ENG-SKP22004-R4-TIS.pdf Markup Summary

Subject: Callout
Page Index: 1
Date: 1/19/2023 9:36:29 AM
Author: dsdrice
Color: ■
Layer:
Space:
Page Label: 1

# 2042 Baseline Average Weekday Traffic

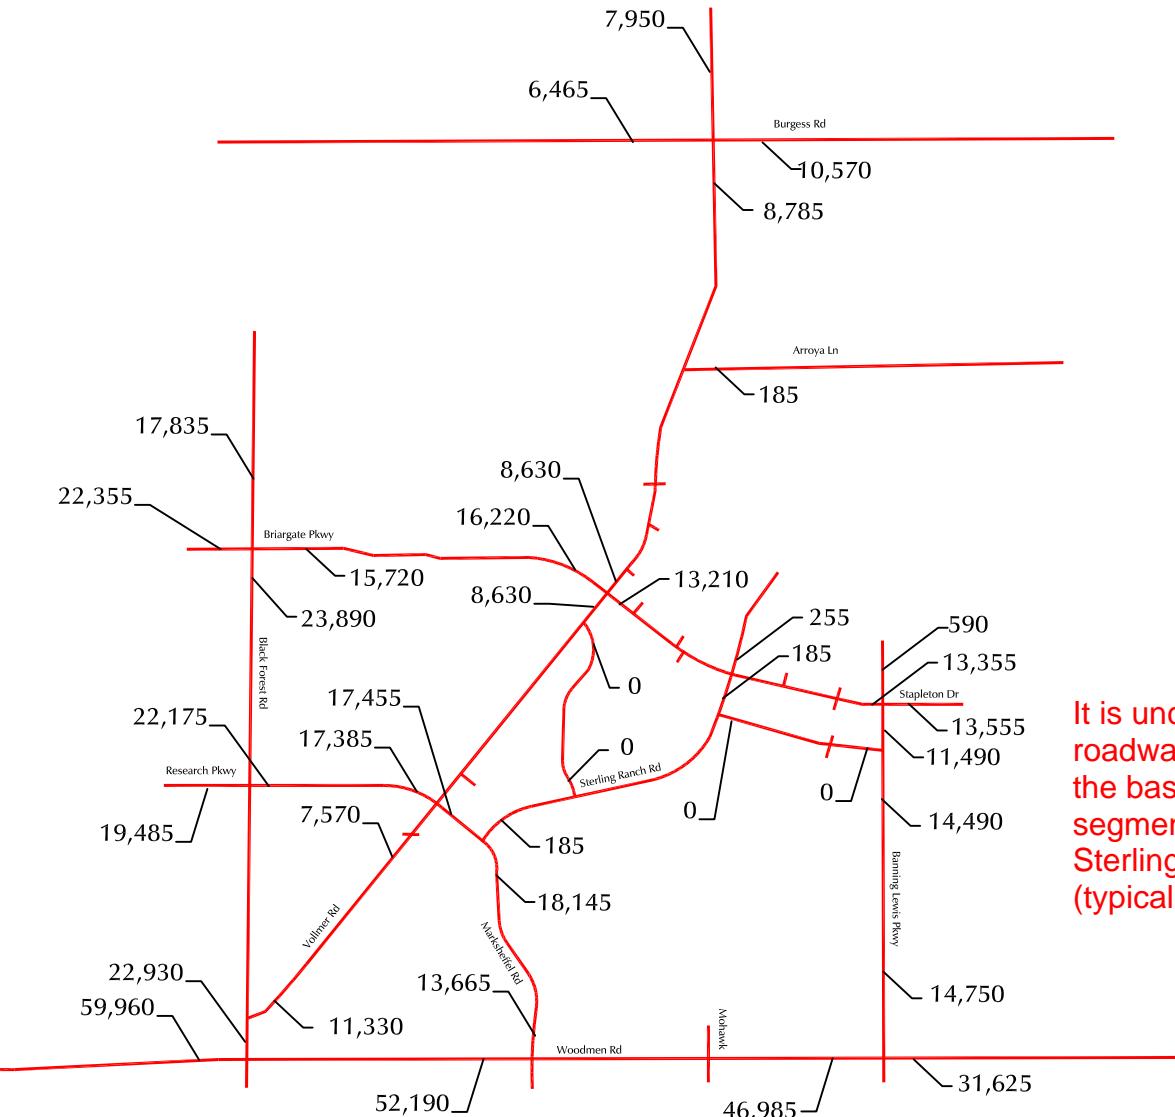
Please clarify what improvements will be in place in the baseline scenario. (State that it is anticipated that Sterling Ranch will build the improvements as development progresses if that is the case.)

2008 TIS TAZ Map

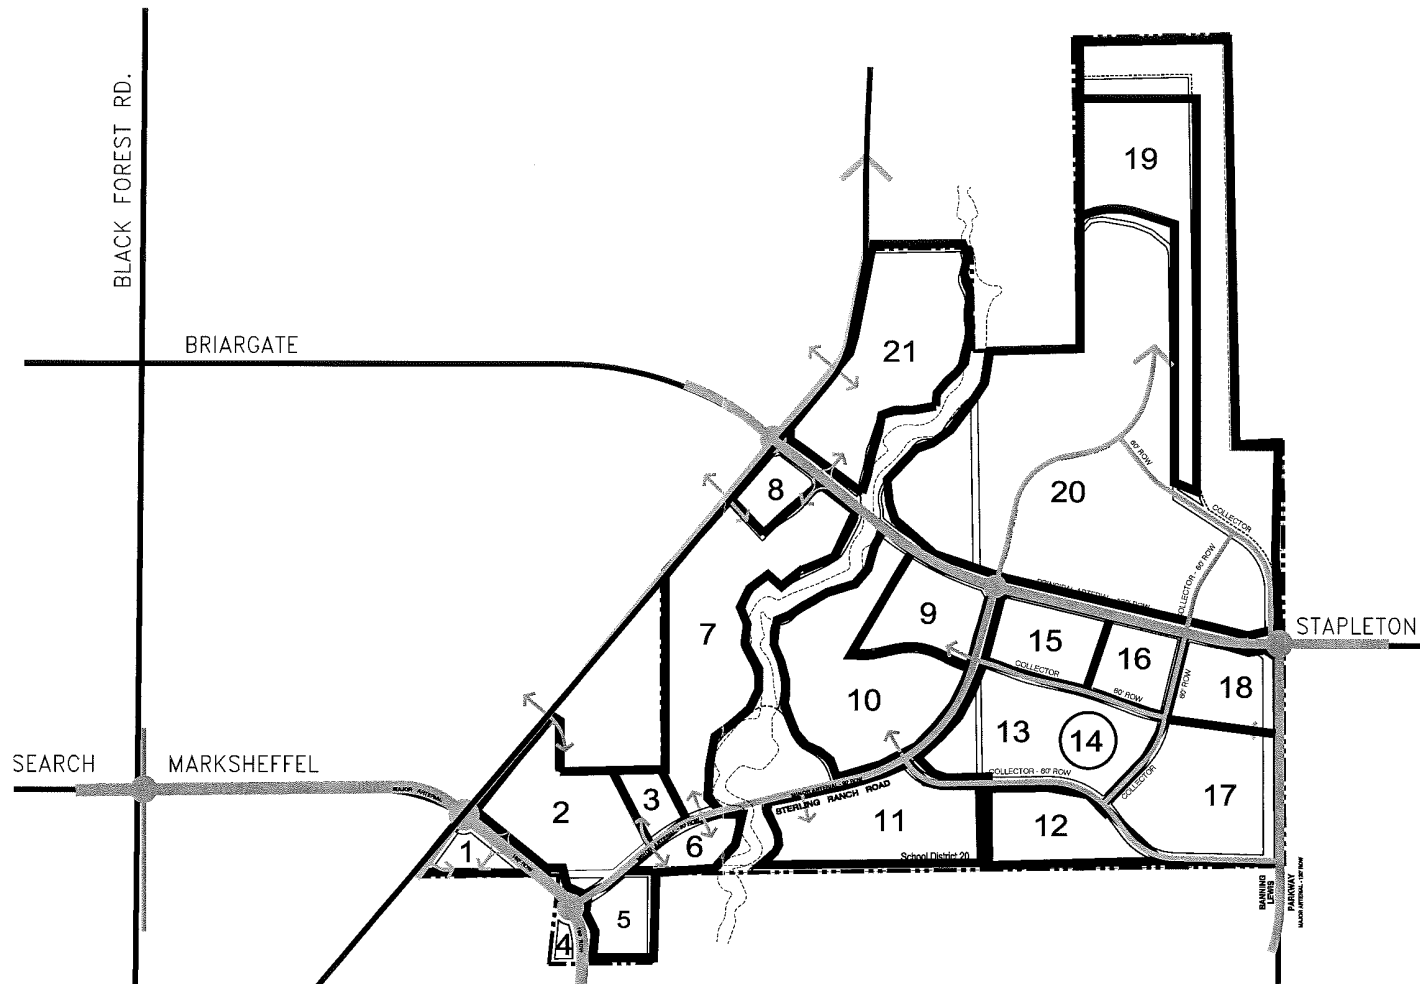
Replace Appendix Figure 2, add
"Conceptual" in the title

Replace Appendix Figure 2, add "Conceptual" in
the title
